CITY OF PORTLAND

May 11, 2001

Re: 32/34 Prospect St. (124 E004) Permit #010024

In response to your request to allow the use of the "attic" space for habitable space, the following are the facts as presented:

4.201 SR1 s Sep 5 2000 MITek Industries, Inc. Wed Mar 07 11:09:27 2001 Page 1

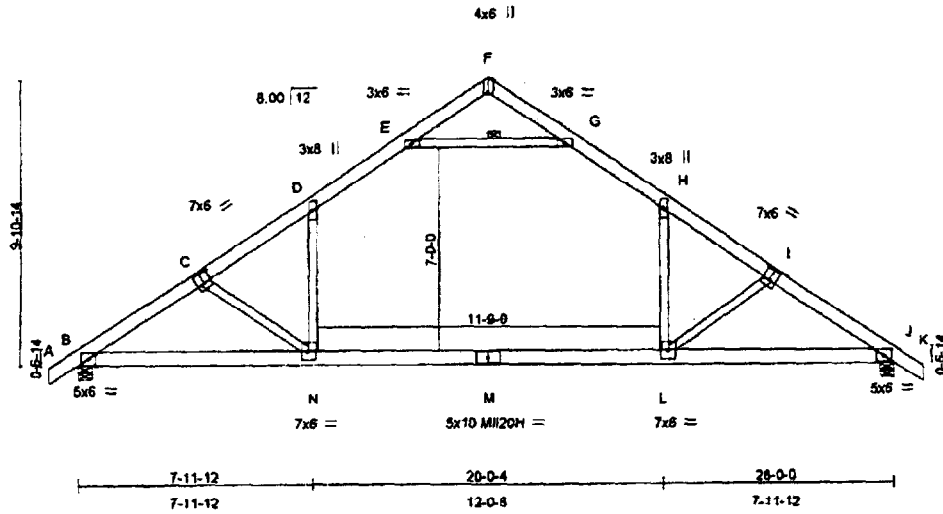
- 1) The use of the structure is a single-family home, Use group R-3.
- 2) The proposed finished ceiling height for the second floor sleeping rooms will be 82 inches.
- 3) The required ceiling height is 84 inches.
- 4) The sloped portion of the ceiling will cover 50.8% of the proposed sleeping area.
- 5) The allowable sloping area is 50%.
- 6) The roof truss system is factory fabricated by Mainely Trusses and cannot be altered without compromising the structural integrity of the trusses.

Based on these facts, and pursuant to Section 121.1 of the City of Portland Building Code, finishing the second floor space in total compliance with the Code would create undue hardship in that the roof system would have to be structurally compromised. The proposal is hereby **granted**. All other aspects of all applicable codes, including, but not limited to, plumbing, electrical, egress, smoke detection, emergency escape and structural loading requirements must be found in complete compliance. Building, plumbing and electrical permit amendments must be applied for and granted prior to the commencement of installation and construction.
